Able Marine Energy Park

Material Change 2

Applicant's Responses to

Written Questions

PLANNING			
Scale:	Drawn By:	Checked By:	Approved By:
NTS@A1	D Almeida	R Crum	R Crum
Date:	07/12/2020	12/02/2021	12/02/2021
Drawing No:	AME-036-10010	Revision:	C

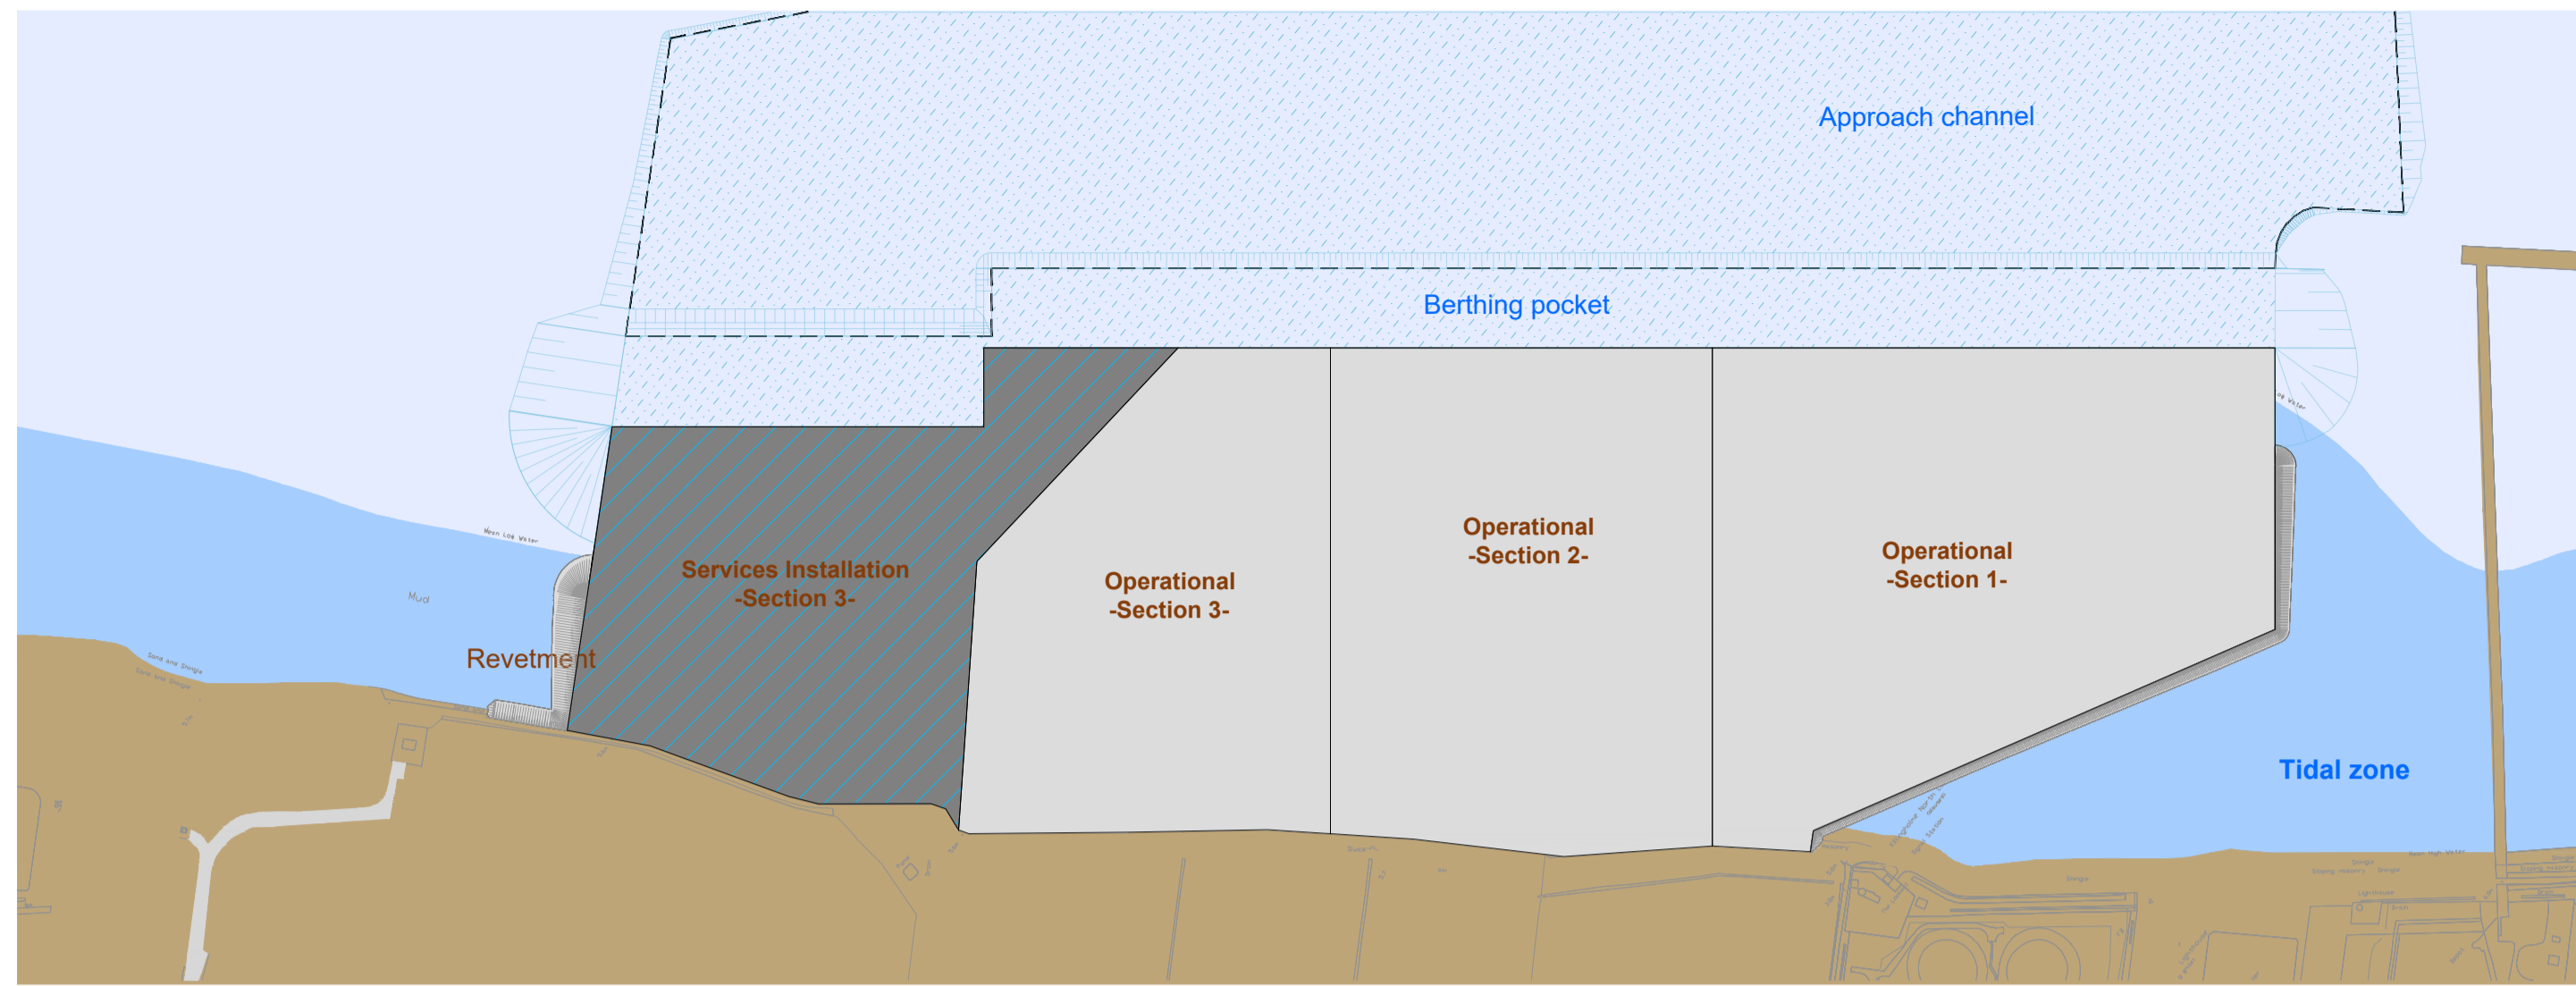
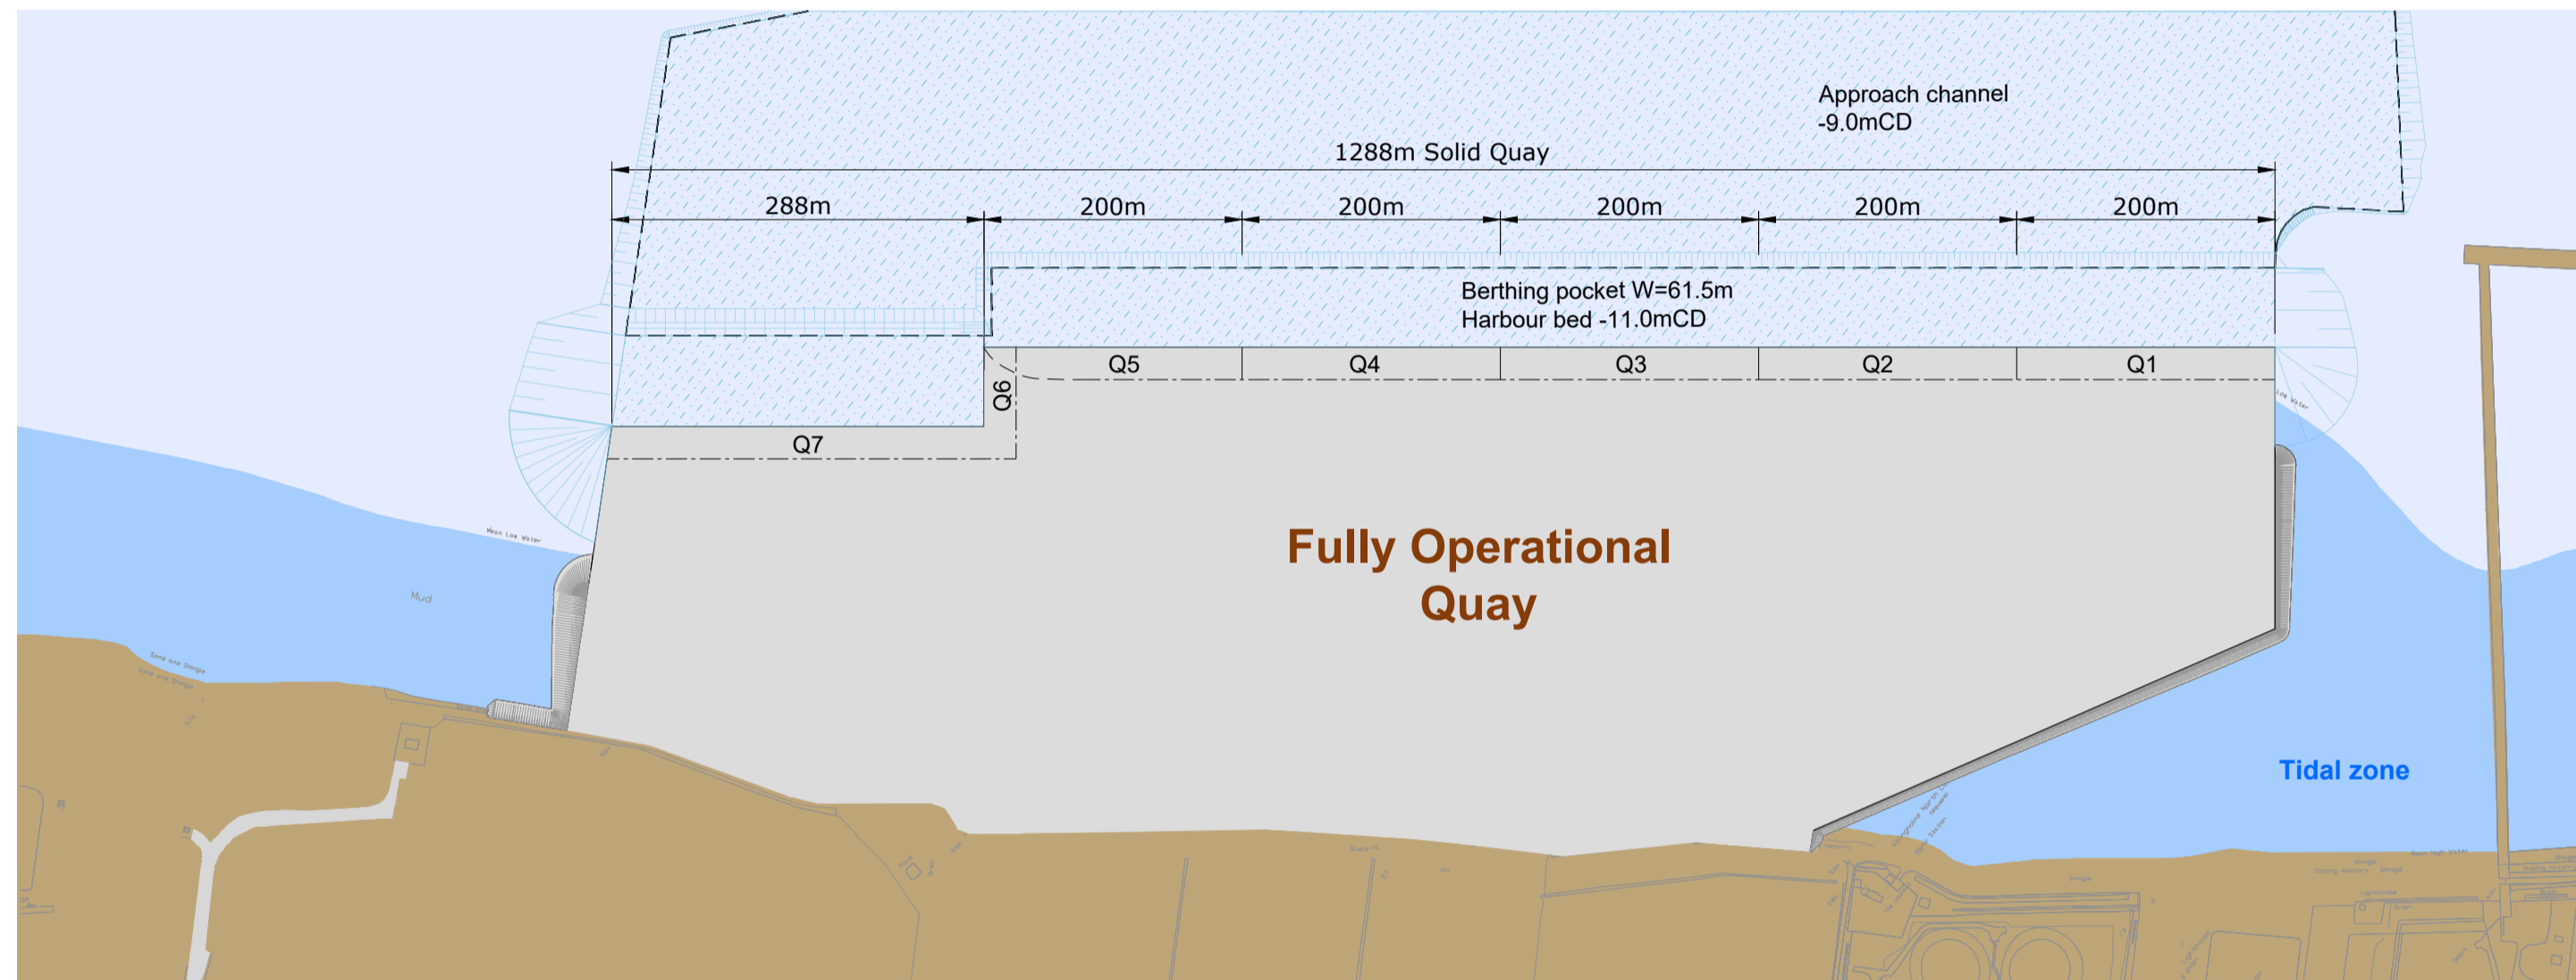
ExQ2	Question to:	Question:	
1. General and Cross-topic Questions			
Q1.01	App	<p>Pease supply A3 size copies of drawings AME-036-10009 rev C and AME-036-10010 rev C.</p> <p>These were previously supplied as A1 size copies when A3 size was requested. (The ExB already has AME-036-10011 rev C as it applies to both construction process alternatives).</p>	<p>The Applicant supplied Revision D of these drawings (AME-036-10009 and AME-036-10010) in response to ExQ1 1.0.1. The draft amendment order (REP1-014) now refers to both the Revision D and the Revision C versions as alternative options.</p> <p>A3 paper versions of Revision C, modified to A3 scale (and amended to Revision C1) have been issued under separate cover and are issued electronically with this response with document references TR030006/D4/2 and TR030006/D4/2A.</p>
Q1.02	App	<p>Re: ExQ1: 1.0.2, For clarity please confirm whether I am right to interpret drawing AME-036-10004 rev C as showing two prime alternatives -</p> <p><i>A: Anchor piles plus horizontal steel ties to quay piles</i></p> <p><i>B: Flap anchors plus diagonal steel ties to quay piles</i></p> <p>That each of these prime alternatives could be built without a relieving slab or could have one of two types of relieving slab –</p> <p>1: With vertical supporting piles without a crane rail beam</p> <p>2: With vertical piles and some diagonal piles supporting a crane rail beam</p> <p>There would, therefore (noting the Applicant's response to ExQ1:1.0.3), be six overall alternatives – A, A1, A2, B, B1, B2.</p>	<p>The Applicant confirms that the Planning Inspectorate has interpreted the drawing AME-036-10004 rev C correctly.</p>
